**S.4.55(1A) MODIFICATION 3, SSD-66777221 – LANCELEY PLACE DATA CENTRE,
MINOR ARCHITECTURAL PLAN MODIFICATION**

This is the **third (3rd)** modification to SSD-66777221 and **seeks minor architectural updates to the switch room and reinstatement of a Lanceley Place crossover.**

DRAWING TITLE
SITE PLAN

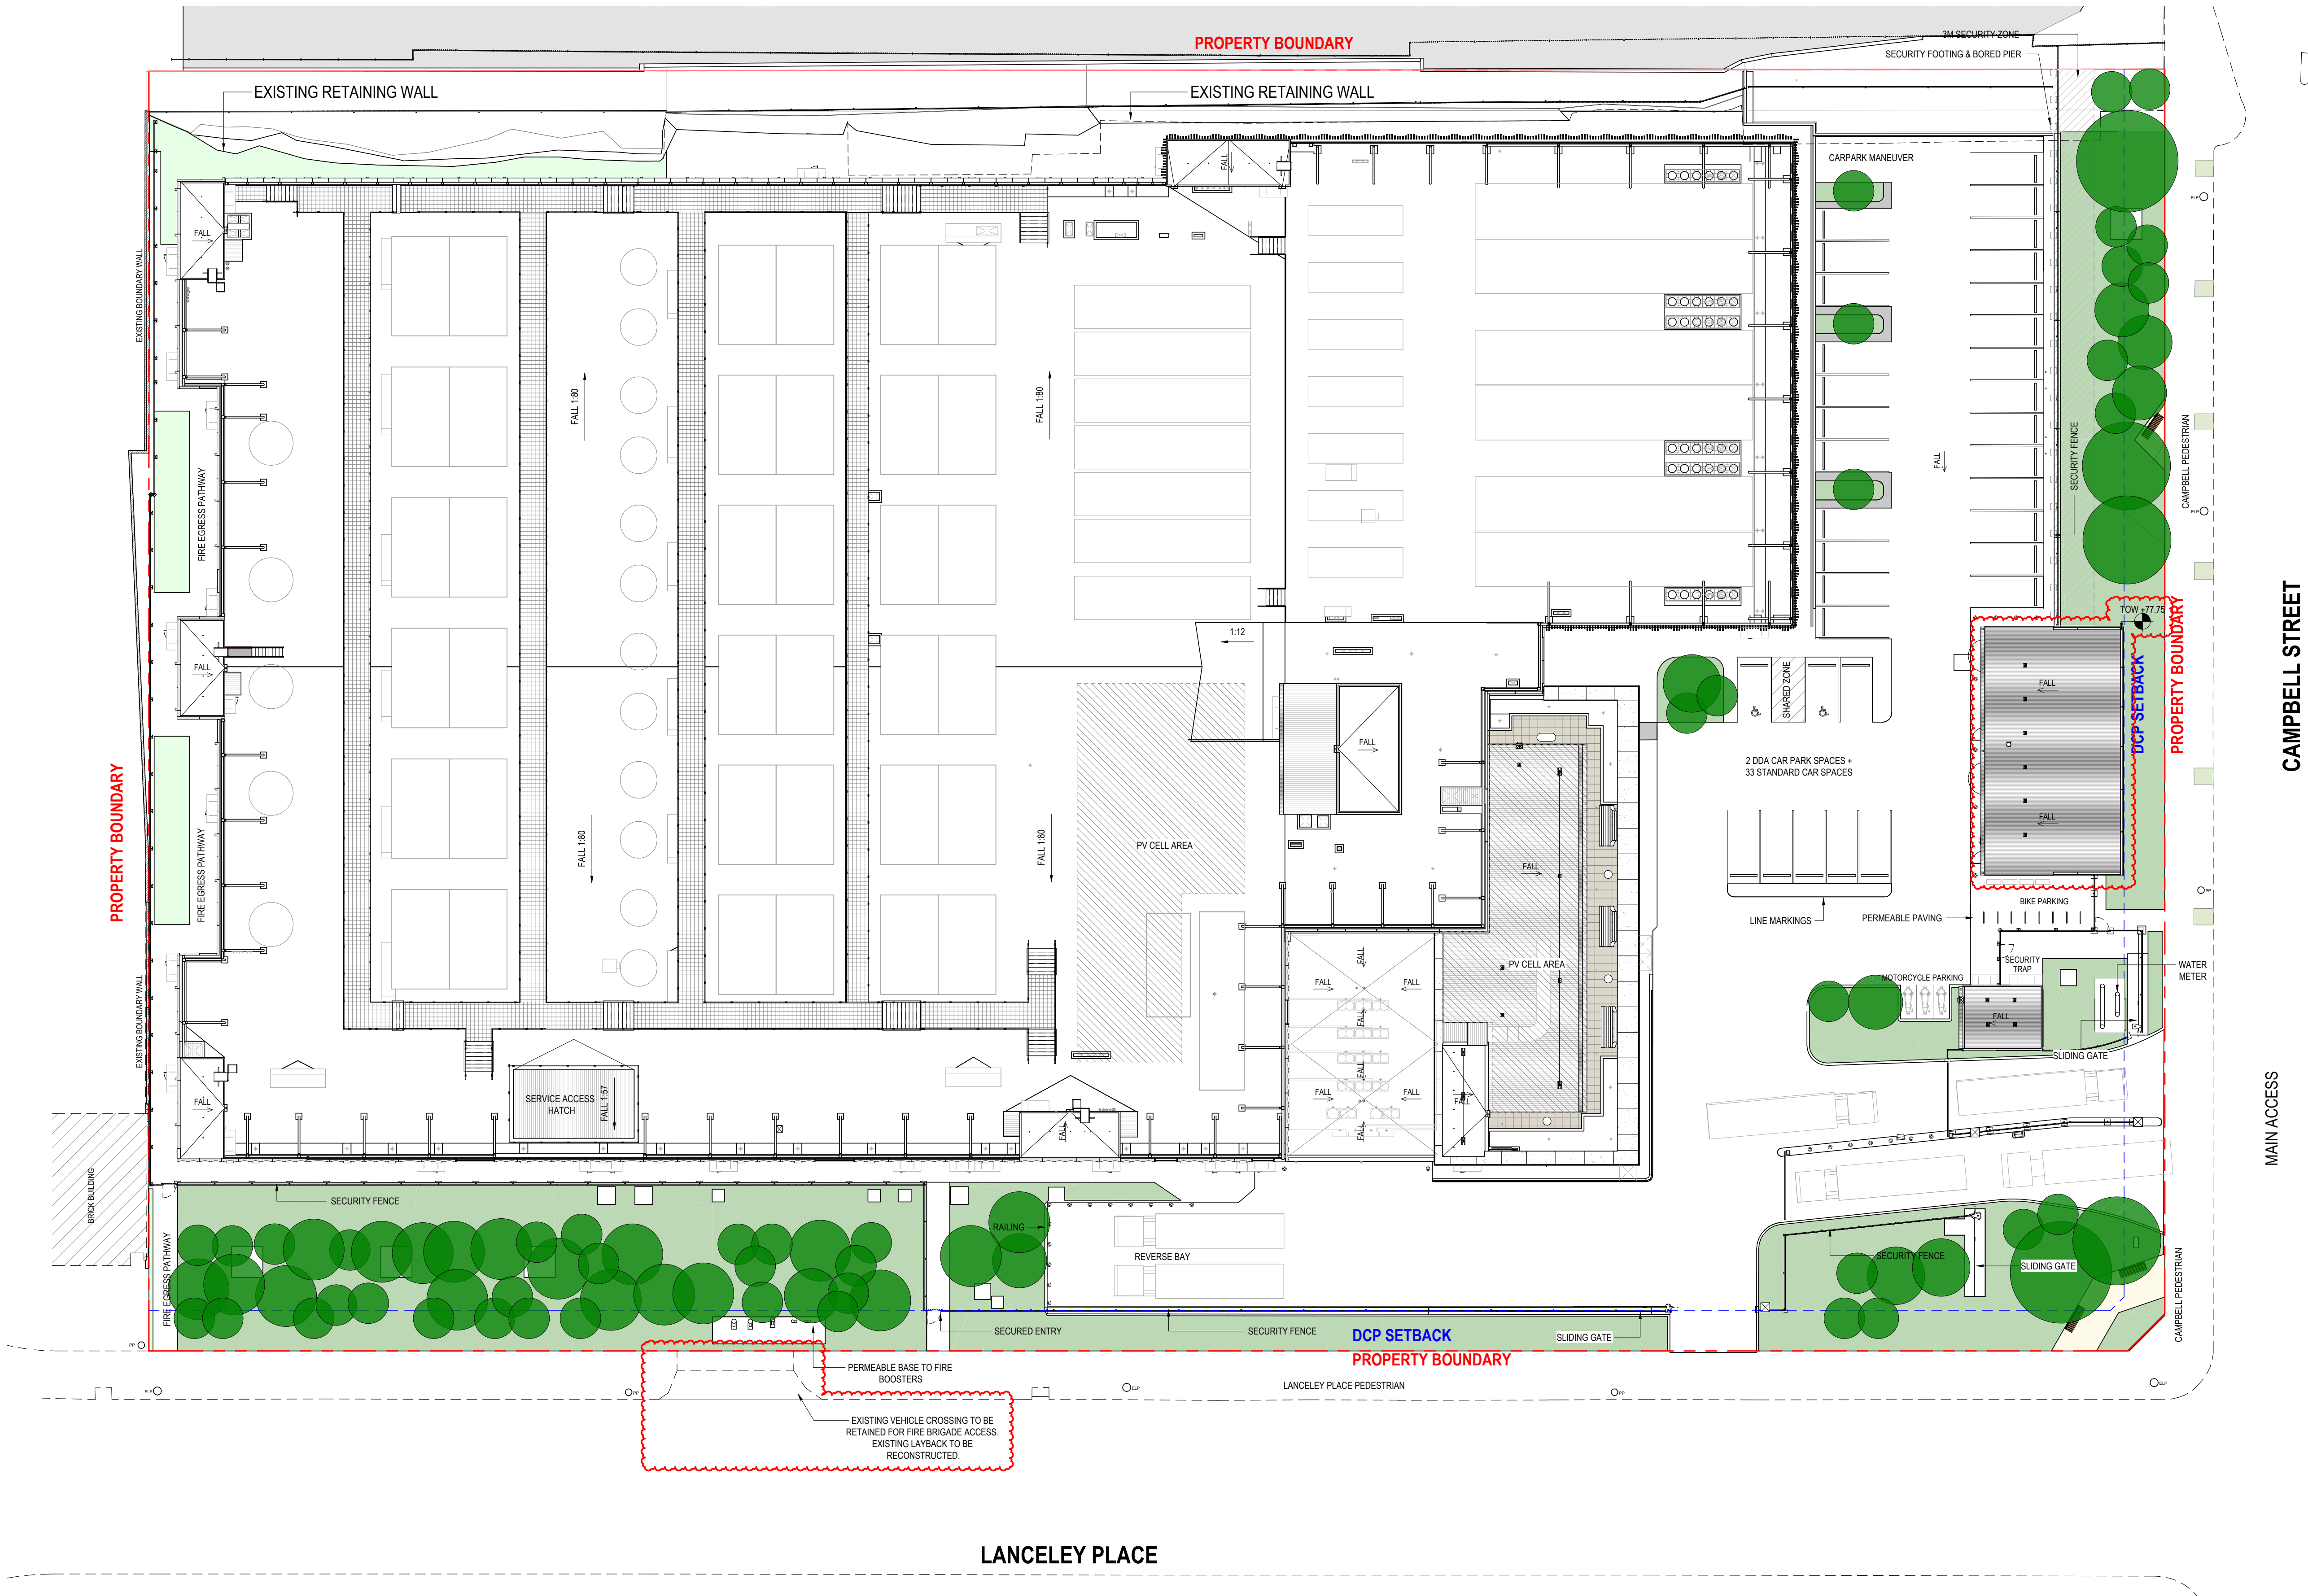
Increase the height of the external switch room located along the site's southern frontage to Campbell Street from 4.045m to 5.250m, an minor increase of 1.205m.

Fire Brigade crossover required along the site's western boundary fronting Lanceley Place, adjacent to the Fire Booster.

It's noted this crossover is existing, however was proposed for removal in previous plans. This MOD seeks to reinstate this crossover for essential booster access.

The approved switch room height was based on generic, vendor-neutral air insulated switchgear. GPSA has now selected Eaton gas insulated switchgear (GIS), which is slightly taller than originally assumed. As a result, an extra 1.205m of vertical clearance is needed to allow components to be replaced from the top and rear.

FRNSW have specific requirements for unobstructed, all-weather access to fire brigade infrastructure, including fire booster assemblies.

Section 8.1.2 of the 'Access for fire brigade vehicles and firefighters' guideline, the designated hardstand area is to be flat and level all weather surface which is clear of any obstructions that could be hazardous during operations (e.g. bollard, railing, fencing, sign, kerb, gutter, fixed structure, parked vehicle, storage, rubbish). Accordingly, and as identified in the approved Fire Safety Study for the Project, FRNSW has requested that the existing crossover adjacent to the booster assembly be retained to ensure safe and efficient maintenance access.
